Mallard Pass Solar Farm

Applicants Responses to Interested Parties' Deadline 2 Submissions - Ecology

Deadline 3 - June 2023

EN010127/APP/9.18

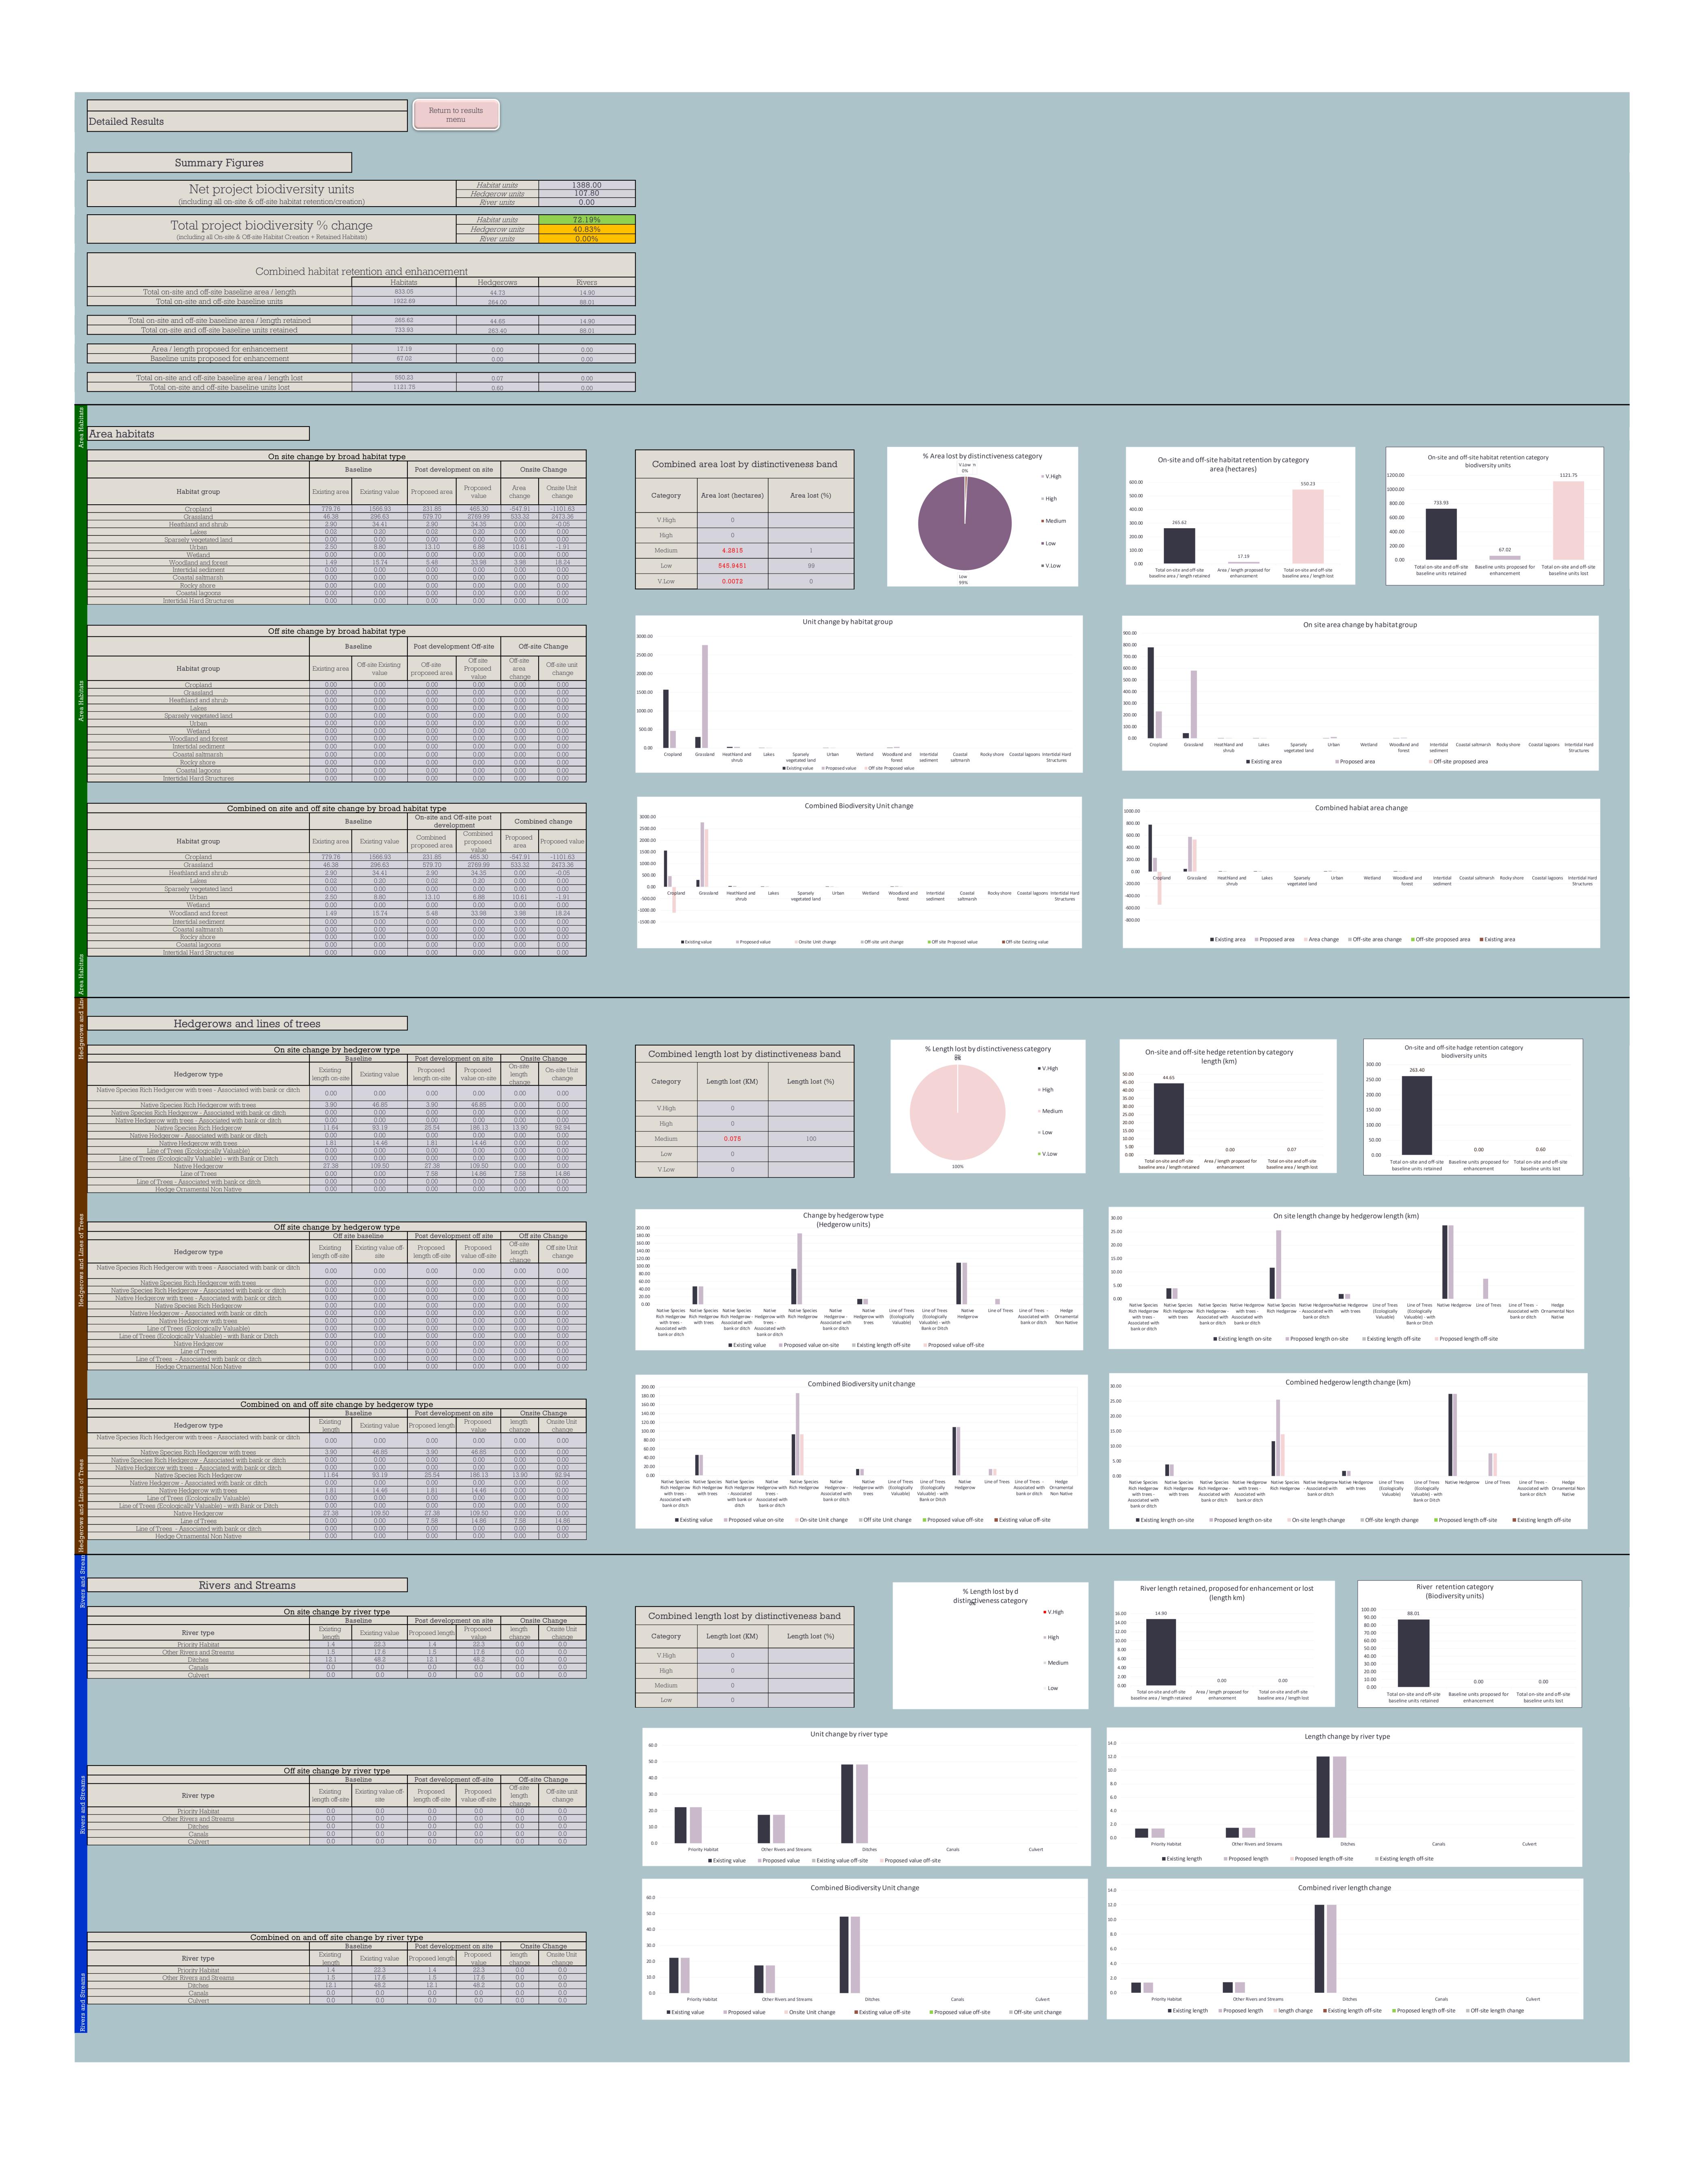
REP2-125		<p>In response to paragraph 2.14.1 of the Applicant's Non-Technical Summary [APP-106], the stated biodiversity net gain of 71% is being questioned. What is this compared against? Is this compared to, for example, a field of wheat (monoculture)? If so, it is an unreasonable figure to include, and seems unlikely in all circumstances. Is it a hopeful or exaggerated figure?</p>	<p>Chapter 7: Ecology and Biodiversity [APP-037] and the Biodiversity Net Gain Metric [APP-064] sets out and are based on the baseline conditions of the site and evaluates the baseline value of the habitats in accordance with the approved metric at the time of submission. This then sets out the assessment of the likely impacts to biodiversity and concludes a gain will be delivered.</p> <p>The Applicant is committed to deliver well in excess of the 'minimum' requirement with this Proposed Development and will not reduce the gain achieved significantly, save for minor adjustments made as the scheme is fine-tuned and landscaping proposals are refined.</p> <p>The DCO mandates a 10% gain, but the Proposed Development will aim to deliver a fair higher gain as set out in the documents mentioned</p>

Parties Raised	Sub-Theme	Issues Raised	Applicant's Response
			<p>above. As the BNG Metric calculations are based on the measures that are in the Outline LEMP, and the detailed LEMP measures are required to be in accordance with that Outline LEMP, reaching well over 10% will be achievable.</p>
<p>REP2-090 REP2-091</p>	<p>BNG</p>	<p>Increase in biodiversity value is a form expectation of policy and not a justification for a solar farm. This increase should be accorded limited weight in the planning balance.</p> <p>The baseline has been incorrectly assessed and the BNG Calculation artificially excludes woodland from the baseline.</p> <p>Concerns over the fact that the scheme fails to avoid harm to biodiversity, including accidental damage.</p> <p>The scheme focuses on habitat creation rather than delivery of measurable long term ecological benefits and outcome.</p> <p>Concerns that field margins were not considered as part of the baseline.</p> <p>Concerns on validity of the BNG if the land is returned to arable after the operational phase.</p> <p>Losses of hedgerow and trees not included in BNG and therefore hedgerow gains are exaggerated.</p>	<p>BNG is not currently a mandatory requirement though achievement of 10% BNG is now becoming a standard requirement by Local Planning Authorities and will be mandated once the Environment Act 2021 is in full force. The Applicant has designed the Proposed Development to deliver far in excess of this and this has been one of the main aims of the design, though retention and enhancement of ecological features of value; and it this large excess that is considered to be a benefit of this Proposed Development. The net gain calculation presented in Appendix 7.6 Ecology and Biodiversity – Biodiversity Net Gain Metric [APP-064] sets this out and shows the large gain in biodiversity terms being delivered. As part of RCC/SKDC LIR, an independent review of the ES was undertaken by Stantec. This review confirmed that the EIA undertaken is considered to be in compliance with applicable EIA legislation and associated guidance and it comprehensively assesses the likely significant effects of the Proposed Development (see Appendix D).</p> <p>Appendix 7.6 Ecology and Biodiversity – Biodiversity Net Gain Metric [APP-064] sets out the baseline (including smaller habitats such as field margins) and captures all predicted losses as a result of the development. Accidental impacts will be avoided and would therefore not be captured by this BNG metric and assessment.</p> <p>In Section 19.21 of their written representation, MPAG have shown a calculation with no supporting text which appears to add the individual values from Area habitats, Ditches and Rivers presented in the BNG metric results into one figure for the pre- and post-development scenarios and then produces an overall figure for biodiversity change. It should be noted that the post-development value for habitats is shown as 1,922.69 (the baseline value, not the post-development value shown in the metric which is 3,310.69) and that this process of “averaging” the</p>
